Arun District Council
Arun Civic Centre
Maltravers Road
Littlehampton
West Sussex BN17 5LF
Planning & Building Control General Enquiries
Tel: (01903) 737756 Fax: (01903) 730442
Dx: 57406 Littlehampton
Minicom: 01903 732765
e-mail: planning@arun.gov.uk
website: www.arun.gov.uk/planning

Application No: AB/126/20/HH
Site Address: 38 Dalloway Road Arundel BN18 9HW
Description of works: Two storey rear extension, replacement windows, replacement cladding, infill to side void & installation of a fence.

Thank you for your internet representation made on 24th December 2020 which has been recorded as an objection with the comments as follows:

BLOCK PLAN
[proposed]

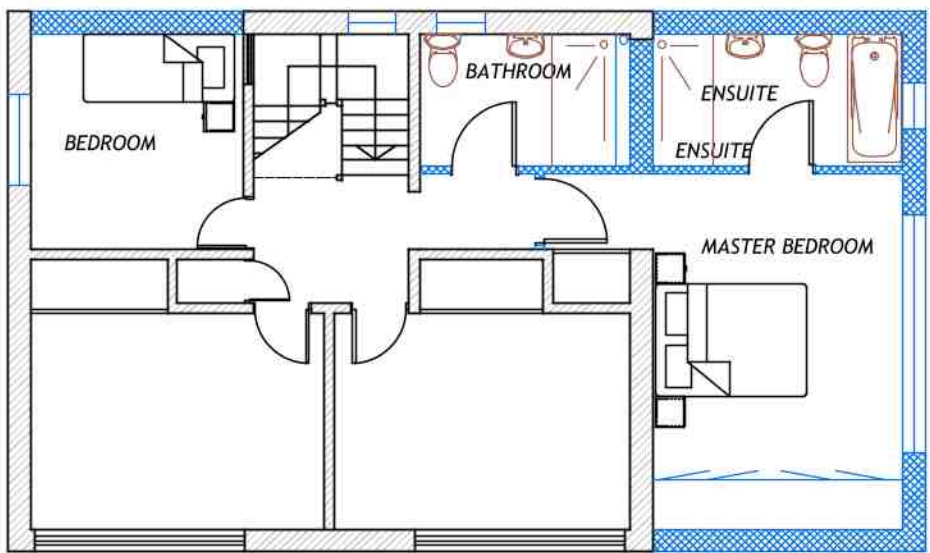
The Committee objected to the Application on the grounds that the proposal will be out of character from the surrounding area of which is kept as an open plan vision. The scale of the size of the second storey will be invasive to neighbouring properties. The use of a 1.8m solid fence would be oppressive and opposing.
